Robert Goodwill MP  
Parliamentary Under Secretary of State for Transport  
Department for Transport  
Great Minster House  
33 Horseferry Road  
London  
SW1P 4DR

**14 November 2013**

**Planning Act 2008  
Proposed Able Marine Energy Park**

PROPOSED ROSPER ROAD LOOP - ASSUMED ROAD LEVELS

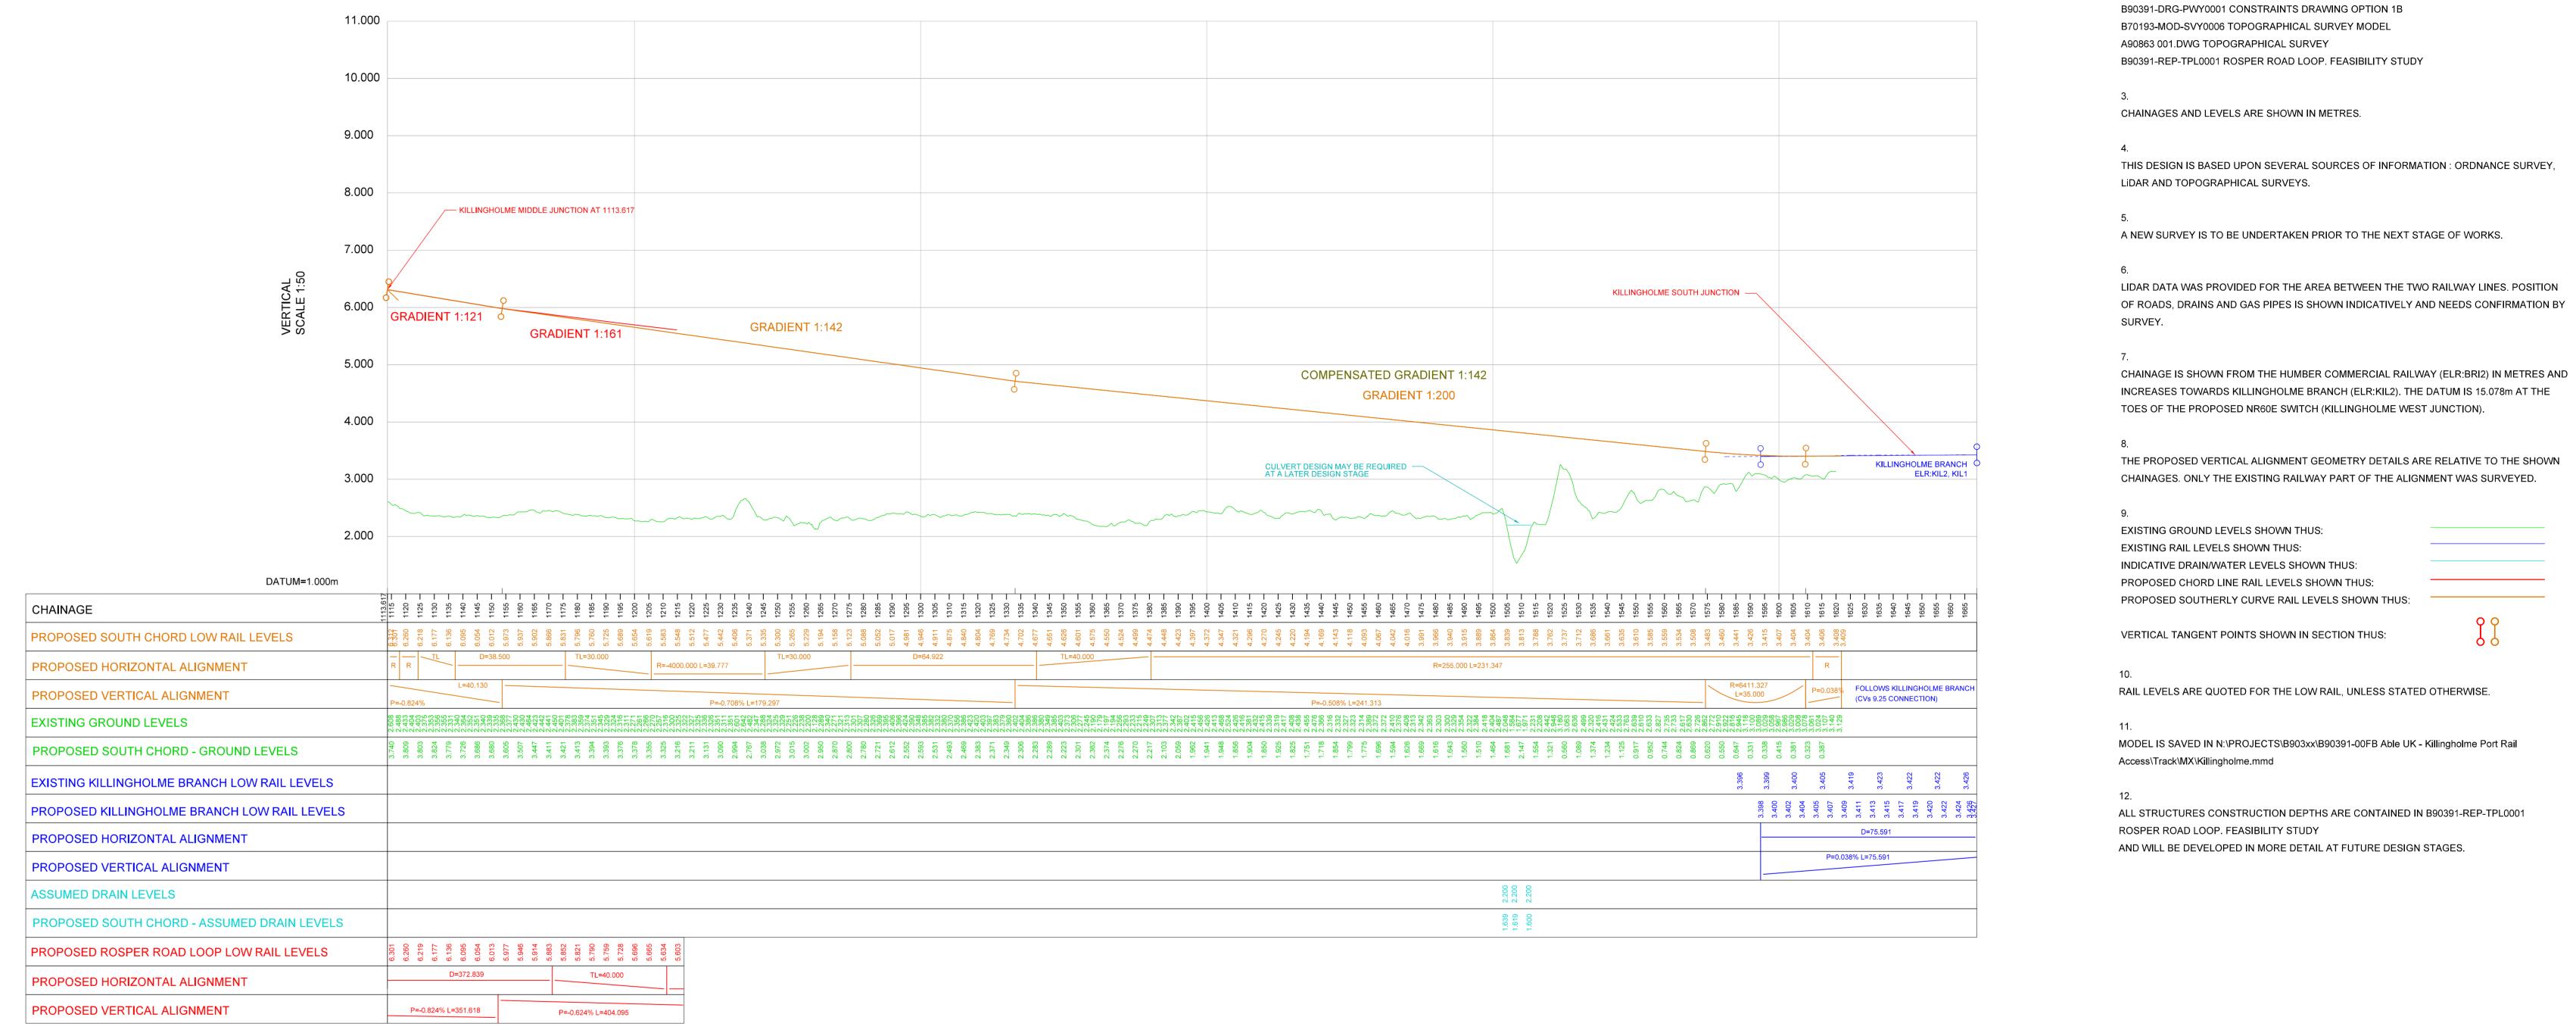
- (b) It is not clear whether the projected costing of £38.4m includes the cost of the “*Indicative connections for CGEN and HIT*” that are shown as dashed red lines on drawing B90391-DRG-PWY0001 Rev P05. For the scheme to function in the way envisaged in the description of operations (section 4.7, page 18), these additional running lines, serving three rail loading facilities, would need to be provided. At best, this places a significant question-mark over the assertion that the RRL is cheaper than the Killingholme Loop.

- (ii) It isn't at all clear how trains departing the C.Ro Ports facility will exit onto the main line. If they head up the RRL, they will be going against the flow of traffic along this single line route. Alternatively if the intention is to route such trains through the existing Port of Immingham lines, there is no apparent way of crossing the lines that are required to access HIT (shown as dashed red lines on drawing B90391-DRG-PWY0001 Rev P05).
